**KIRKLEES METROPOLITAN COUNCIL
INVESTMENT & REGENERATION SERVICE**

DELEGATED DECISION TO DETERMINE PLANNING APPLICATIONS

| Reference No: | 2023/62/91935/W |
| Site Address: | 2, Kirk Lea Crescent, Lindley, Huddersfield, HD3 3HF |

Drawing	Plans as proposed
Job No.	2
Rev.	A/B

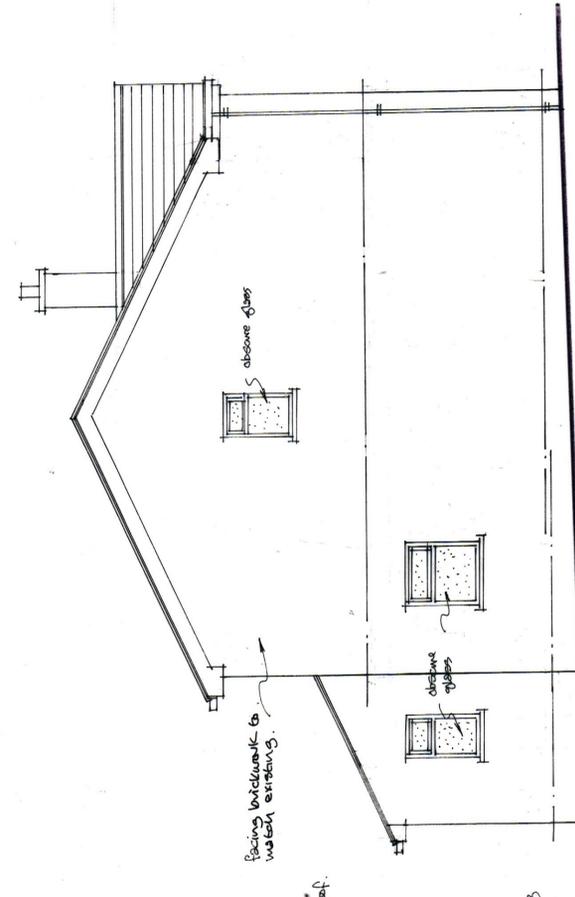
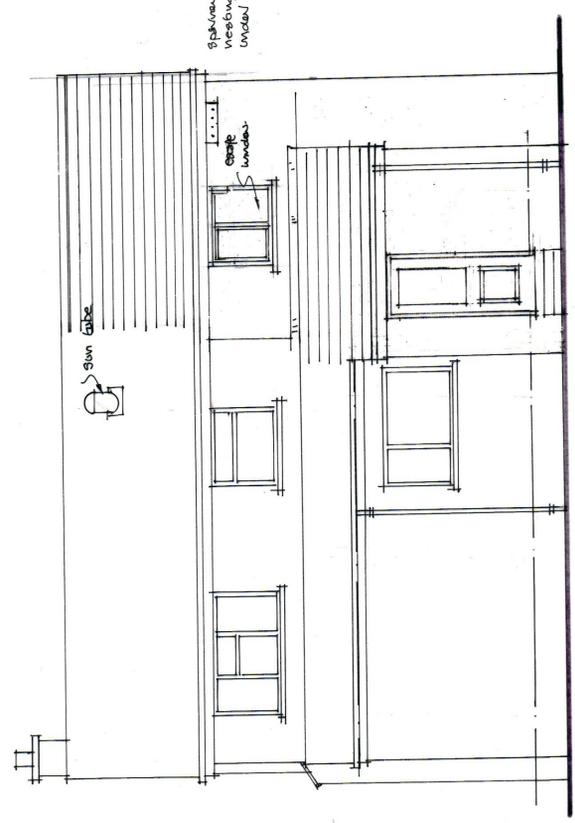
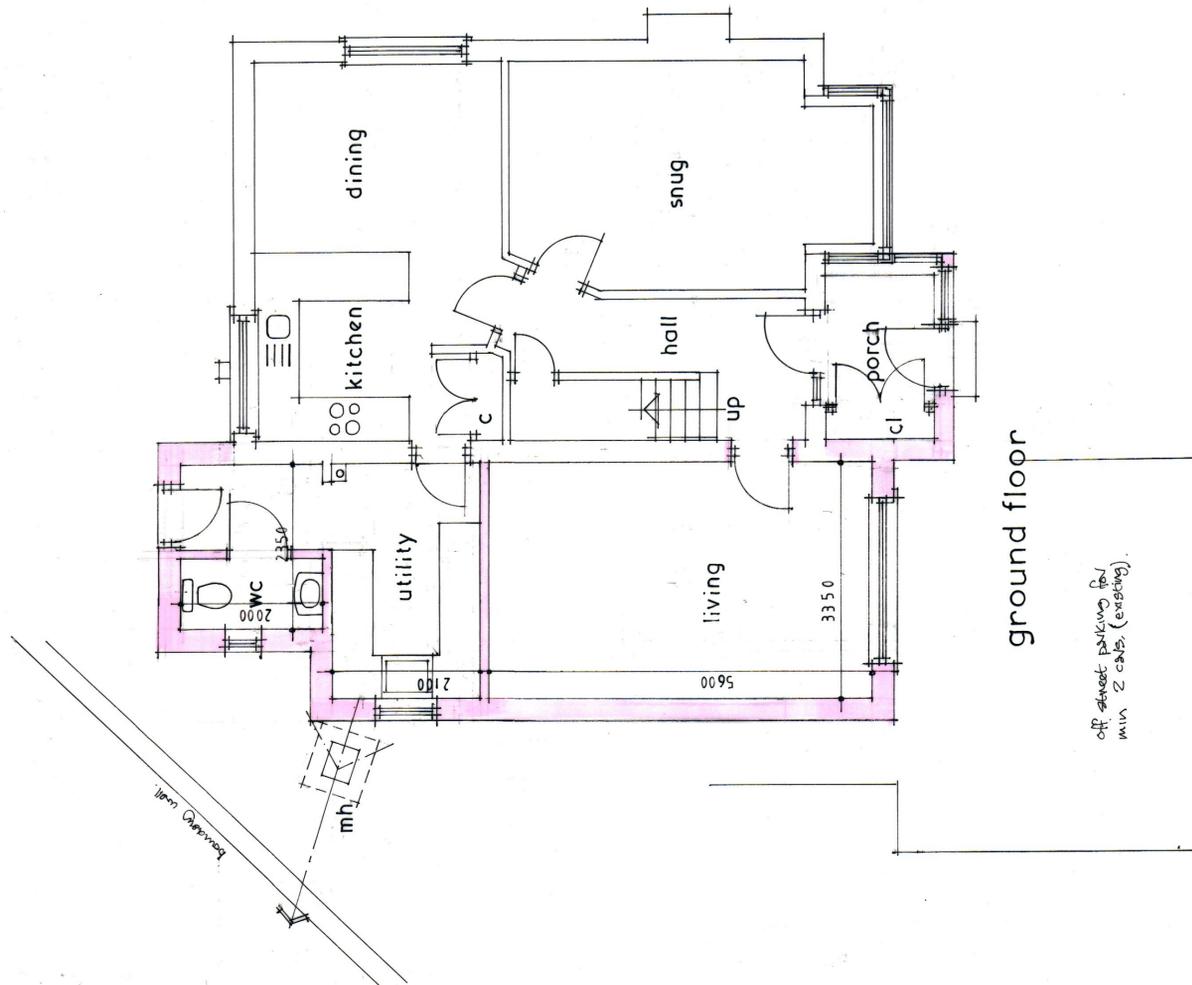
For reasons of visual amenity, the case officer recommended that amended plans be submitted showing the extensions to be faced in materials that match those to the exterior walls of the host property.

Whilst it is noted one elevation is annotated both with render and matching materials, it is considered this can be confirmed / clarified by a condition placed on any grant of permission.

In response, the applicant/planning agent submitted amended plans to show the extensions to be faced in matching brickwork.

3. Notwithstanding the plans submitted, the external walls and roofing materials of the extension hereby approved shall in all respects match those used in the construction of the existing building and be thereafter retained.
Reason: In the interests of visual amenity and to accord with Policies LP2 & LP24 of the Kirklees Local Plan, Principles 1 and 2 of the Council's adopted House Extensions and Alterations SPD and policies within Chapter 12 of the National Planning Policy Framework.
